DECISION DELEGATED TO DEVELOPMENT MANAGER

Application No: H23-0821-21 **Applicant:** Mr C Attewell

Proposal: Proposed porch extension to front elevation, addition of cladding & rendering, changes to windows to front elevation and bi-fold doors to rear.

Location: Fir Tree House Dowsdale Bank Shepeau Stow

TITLE:
Proposed Floor Plans

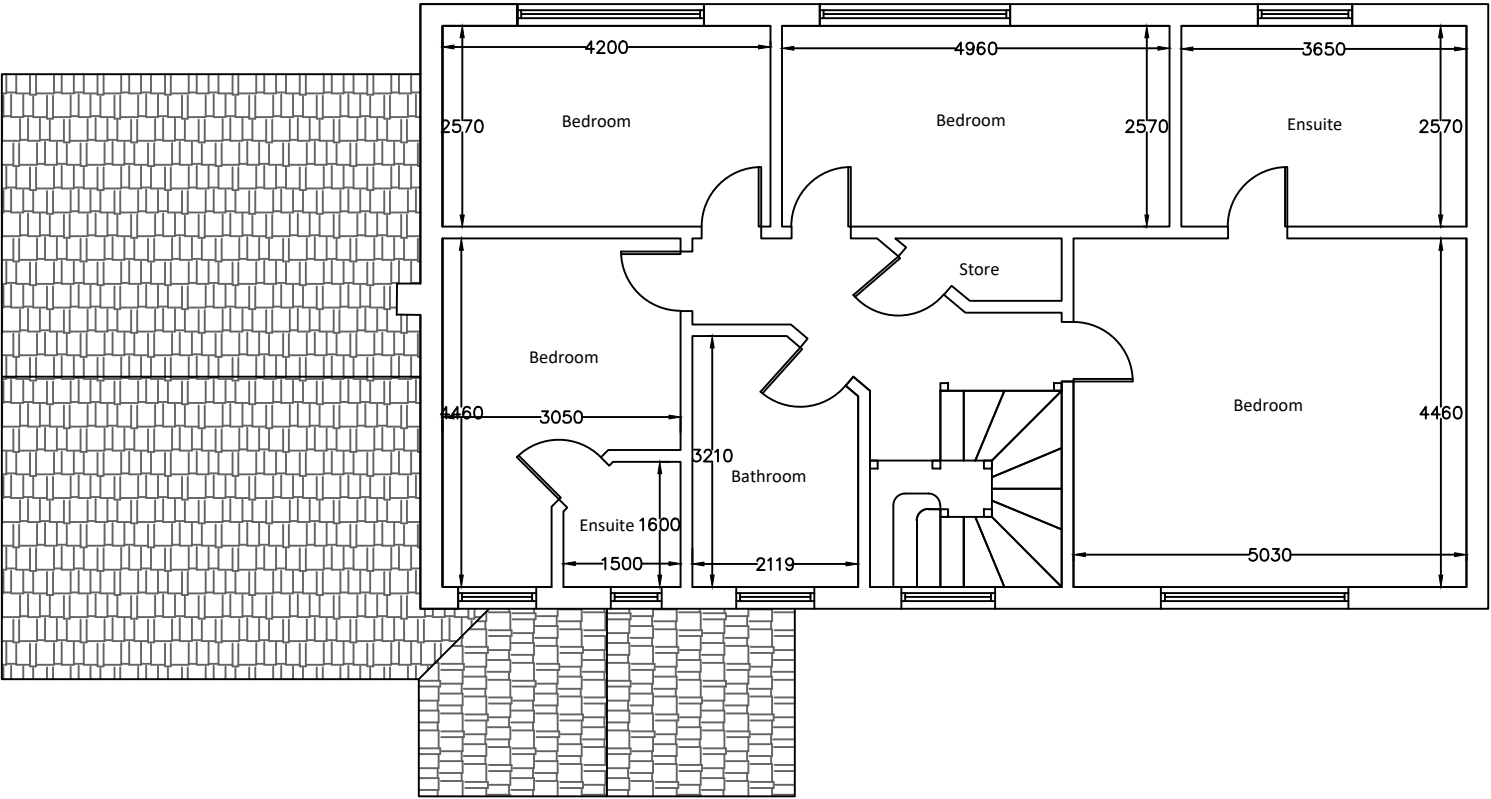
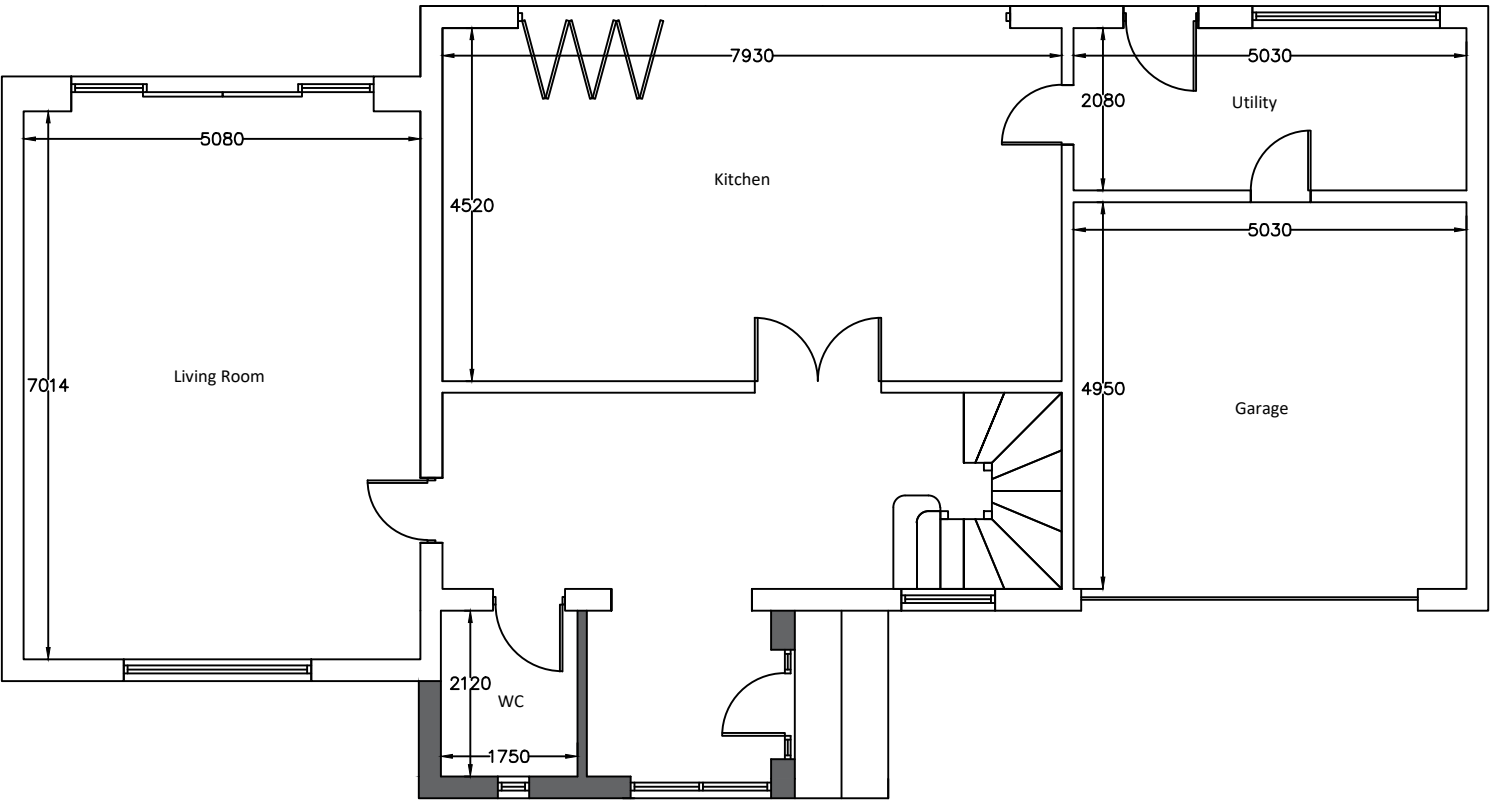
This is a householder application seeking permission for a front porch extension measuring 1.5 metres (depth) x 4.8 metres (width) and standing at 3.9 metres in height (2.3 metres to the eaves). It would have a render finish. The scheme also proposed fenestration changes on the front and rear elevations as well as cladding on the upper half of the existing house and render on the lower half.

The proposed porch would not unacceptably impact neighbouring amenity given its small footprint and distance from neighbouring properties.

PROPOSED FRONT ELEVATION

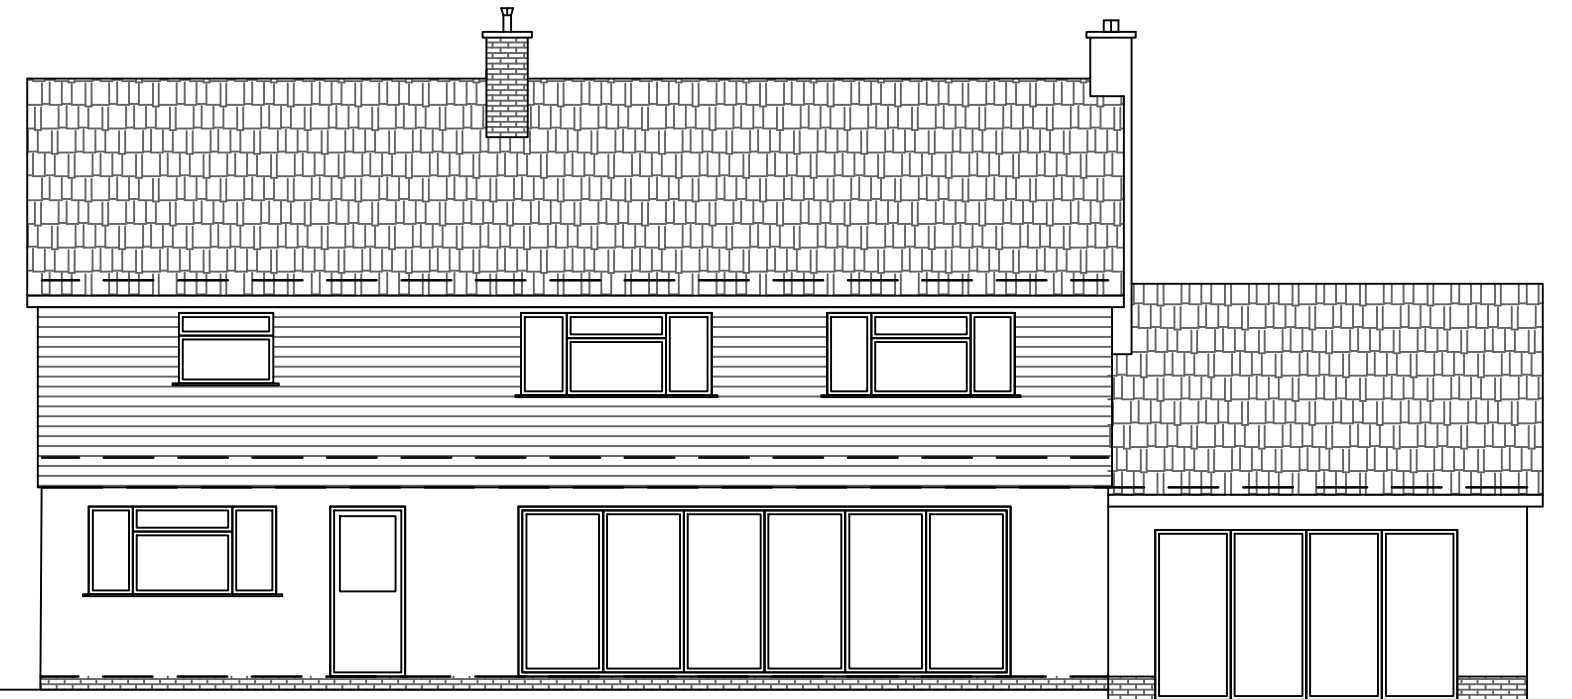
The front porch extension would have a relatively minor footprint and would appear as a small addition to the existing frontage. Given its setback from the front boundary it would not appear overly prominent in the street scene. As such the proposed front porch extension is acceptable in terms of scale, mass and bulk.

The proposed fenestration changes on the rear elevation can be done under permitted development. The changes on the front elevation and addition of a full length window would create an unbalance on the front elevation, however, it can on balance be accepted as it is not considered to significantly or unacceptably change the overall appearance of the dwelling.

The proposed render and cladding are also considered acceptable given there are a mixture of different materials in the area therefore the development would not be out of character with the area.
